Application number: 2019/91609	
What is the application for?:	Outline application for erection of residential development
Address of the site or building:	adj, Marsh Conservative Club, Abb Street, Marsh, Huddersfield, HD1 4PB
Postcode:	HD2 1QN

SITE PLAN  
1:200

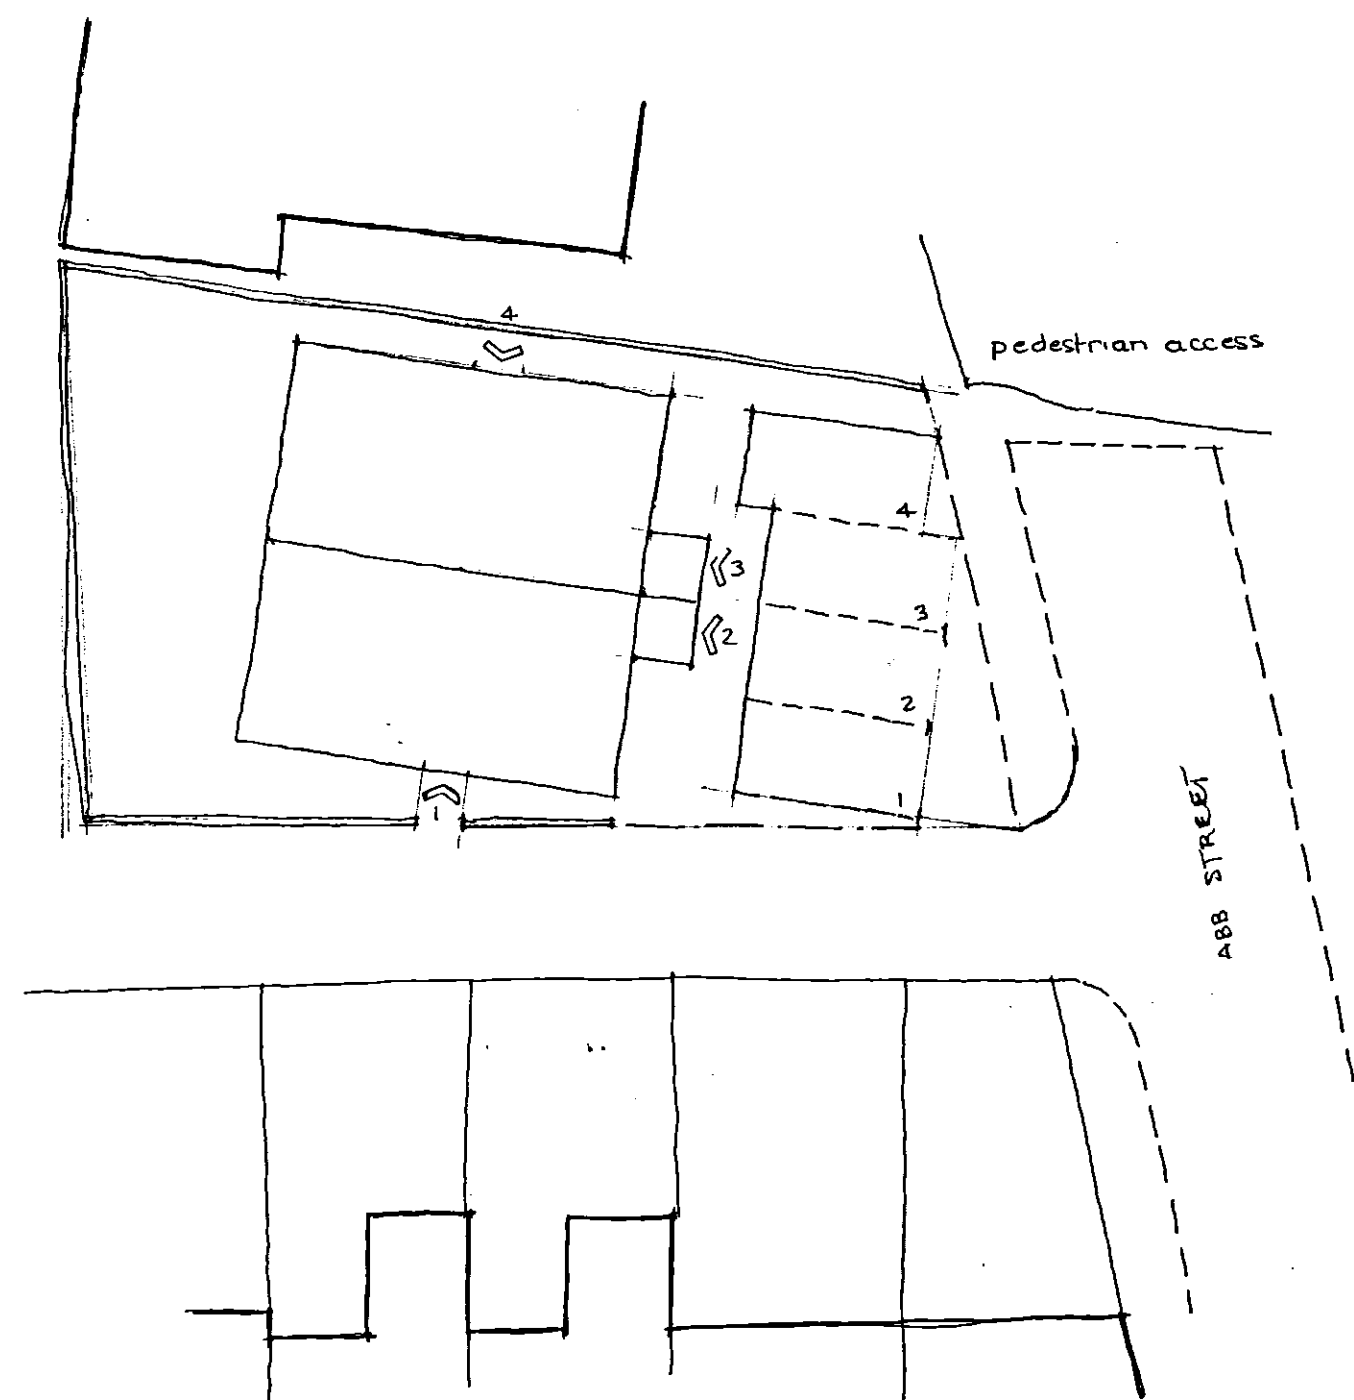
Type of comment: An objection
My main concern, is that access to the parking spaces is across the length of the pavement, and so would reduce on street parking and access to the main entrance to the Con Club (not the rear entrance as stated in the Highways report).
